From: Simon Davis
Sent: 12 March 2020 10:25
To: Planning Scanning
Subject: FW: BE/137/19/RES The Cottage, Shripney Road

From: Simon Davis
Sent: 12 March 2020 10:22
To: 'Ben Daines' [REDACTED]
Subject: RE: BE/137/19/RES The Cottage, Shripney Road

6.06 Plot 17-20

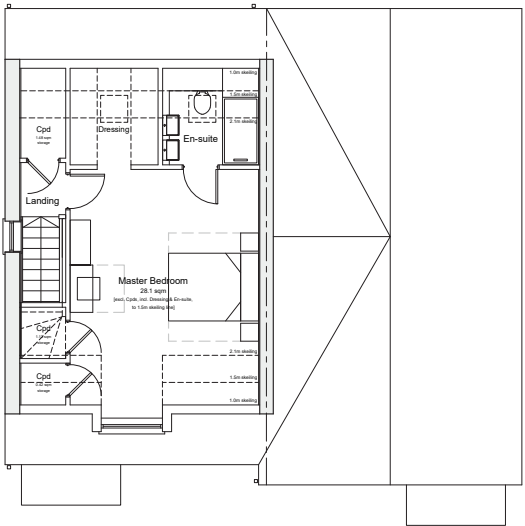
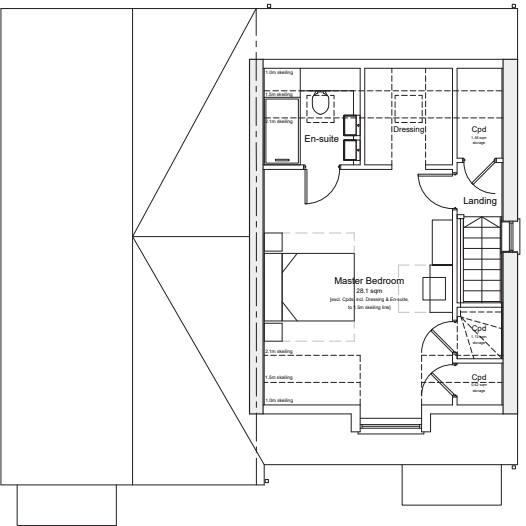
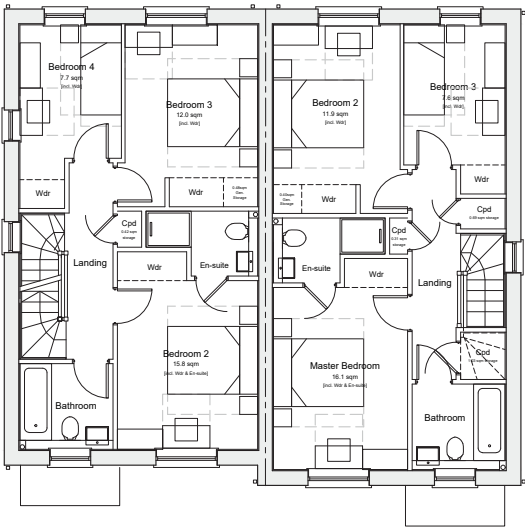
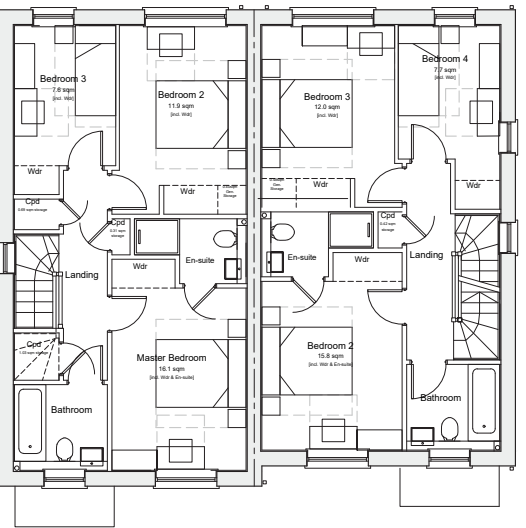
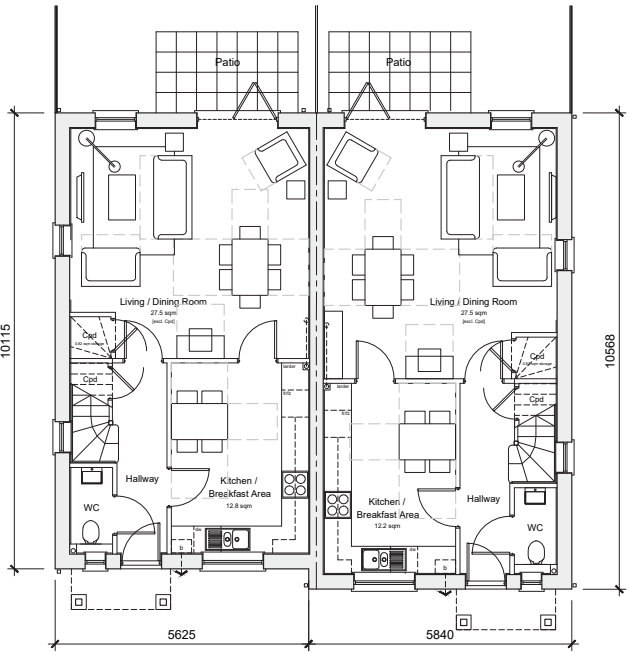
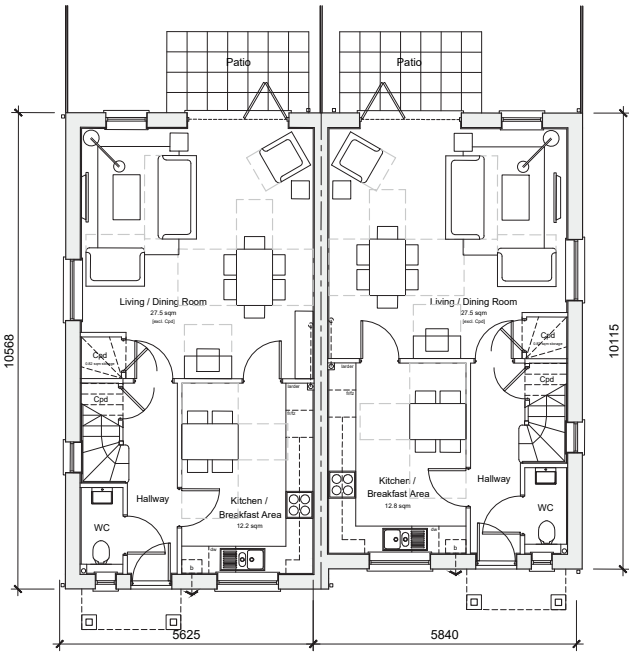
Visitor Parking – I have seen your email. What do you mean by timed restrictions/how would this work? Can you suggest a condition which you consider meets the tests (in particular is enforceable).

Please also note that there were concerns with how the parking will work with plots 17-20 given that the on-street visitor spaces are closer to their front doors. I understood this issue to be addressed via my email of 6 February where we agreed to implement timed restrictions on visitor parking as suggested by WSCC. Also that plots 11 & 14-16 are facing onto car pots are not great from an amenity perspective. It was suggested that you could turn units 17-20 by 90 degrees to face the new road. We would not refuse due to these concerns but you may want to consider. We may however have to refuse due to the other concerns if you cannot resolve these. Happy to speak by phone next week.
